Recommendation Report for Planning Permission for Works or Extension to a Dwelling

REF NO: AW/41/19/HH

LOCATION: 28 St Richards Way
Aldwick
PO21 3BB

PROPOSAL: Proposed two storey extension at rear, front extension to garage and new window to front elevation

South-East Elevation
(Rear)

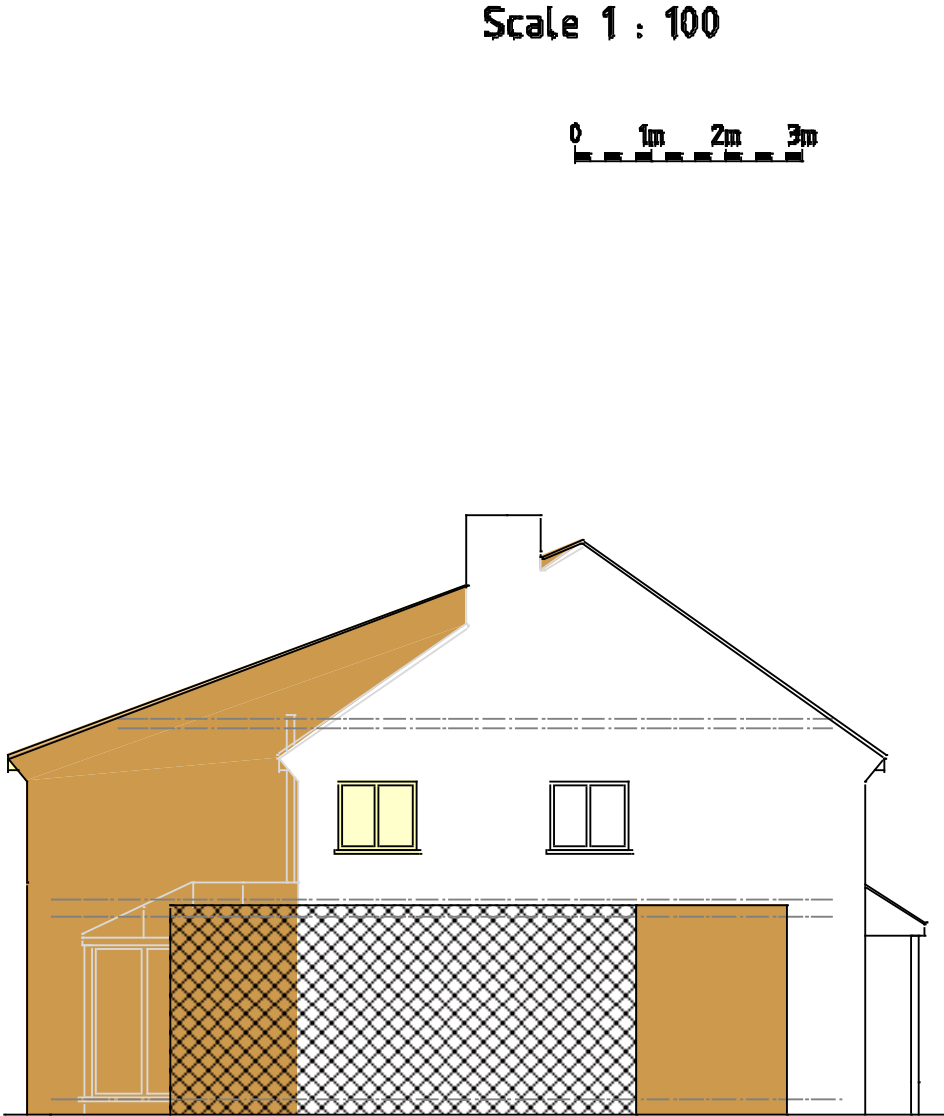
There is currently a conservatory to the rear however this will be removed and replaced with a two storey extension. This will have a depth of approximately 3.6m and extend the full width of the rear elevation. The height will match that of the host dwelling with it extending to slope the full depth of the extension with the eaves to match that of the existing property.

Whilst this does add bulk to the rear of the property it does not extend beyond the rear elevation of that at No.30 and retains 3m to the boundary to the north-east. The extension does extend slightly beyond that of No.26 however with a garage sited at the boundary it is not considered to appear adversely overbearing upon neighbouring amenity. Due to the siting it is also not considered to give rise to any adverse overshadowing upon neighbouring amenity.

There are 2 first floor windows proposed to the rear elevation of the extension. With 1st floor windows already in existence they are not considered to increase overlooking significantly from that which can already be achieved.

South-West Elevation

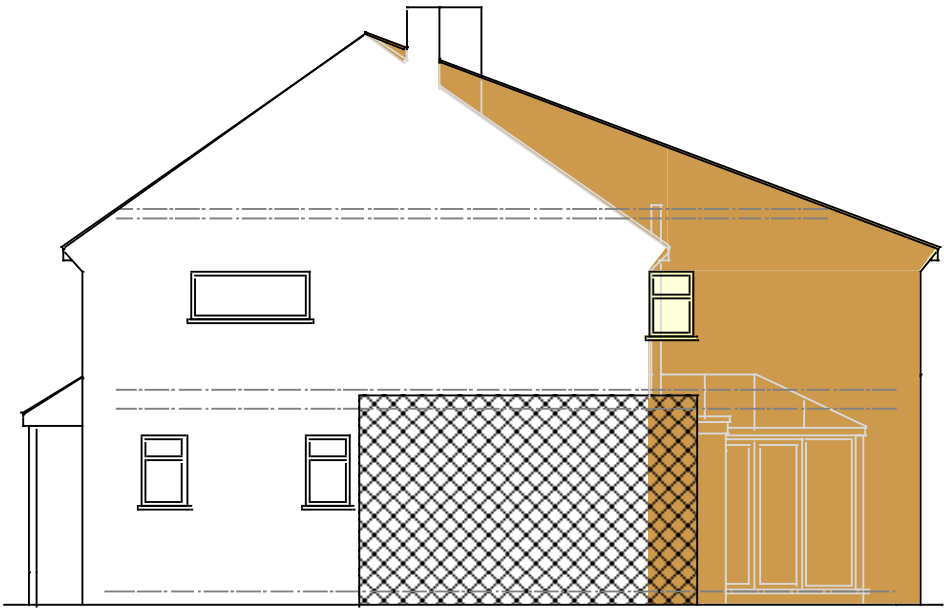
There is also a window proposed to the north east and south west elevation. With no windows located to the side elevation of the neighbouring property to the north east and due to its siting it is not considered to give rise to adverse overlooking. With a window located to the side elevation of No.26 there may be possible overlooking and therefore it will be conditioned that the window should remain obscured and fixed shut blow 1.7m to ensure there is not harm to amenity.

- 4 The first floor window on the south-west elevation of the building shall at all times be glazed with obscured glass and only openable at a high level at least 1.7m above finished floor level.
Reason: To protect the amenities and privacy of the adjoining property in accordance with policies DDM1 of the Arun Local Plan.

North-West Elevation

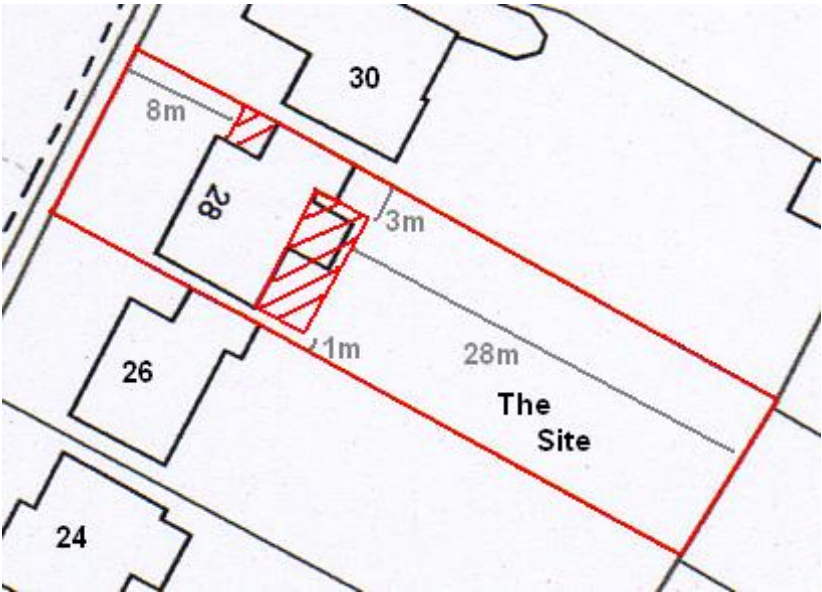
The garage will have an extension to the front and this will increase in depth by 2m. This however does not extend beyond that of the principal elevation and retains 8m to the front boundary. It is therefore not considered unduly dominant and with surrounding properties of a varied design and style the proposal is therefore not considered to appear out of character with the area.
